## 70 Anderson Street

In review of the landscape plan for the proposed 70 Anderson Street the following tree & landscape recommendations would improve the project:

L1.0

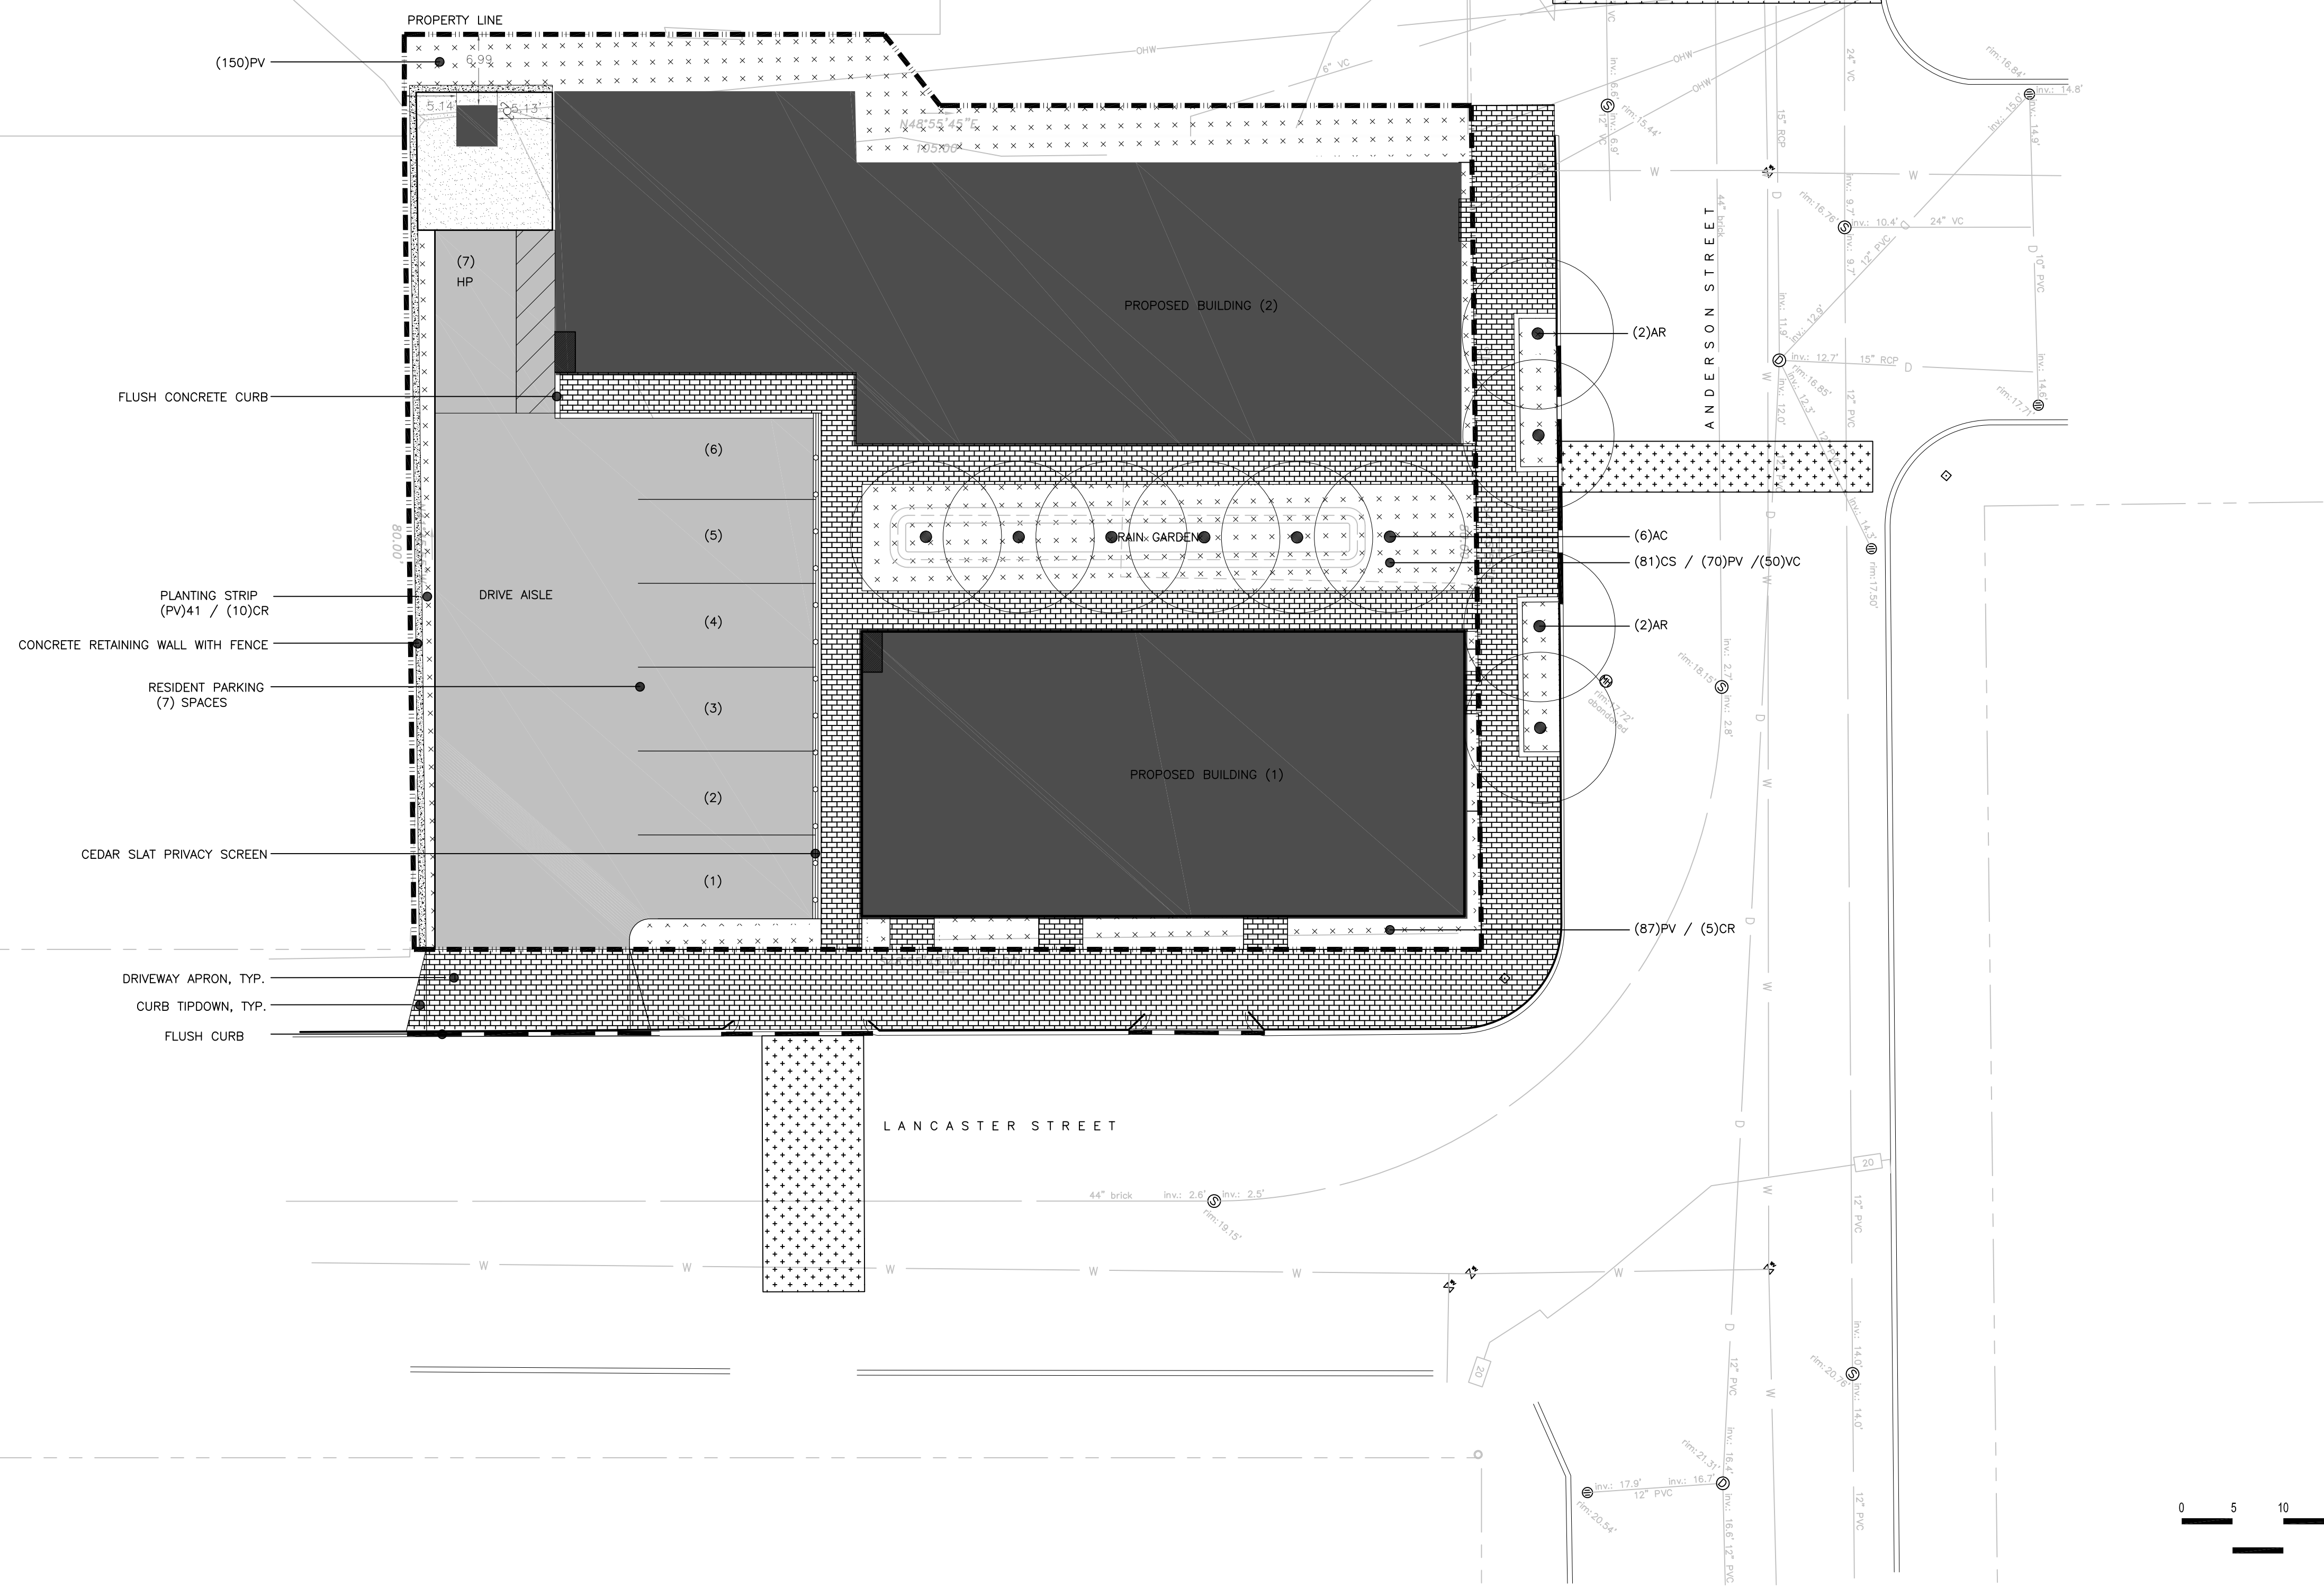
- \* Street-trees - extend the street tree planting to include Lancaster Street as well as Anderson Street. After taking a closer look the space is too tight or restrictive to include two trees in the tree planters.
- \* Tree planters should not be raised due to on-street parking, they should be rectangular in shape 4' x 7' ideal.
- \* Landscape treatment should be considered for the area near the parking lot.
- \* Ornamental grasses proposed for the 5' boarder is acceptable, applicant may want to consider alternatives, woody plants or herbaceous plant material / perennials that offer flowers / texture and year around interest.
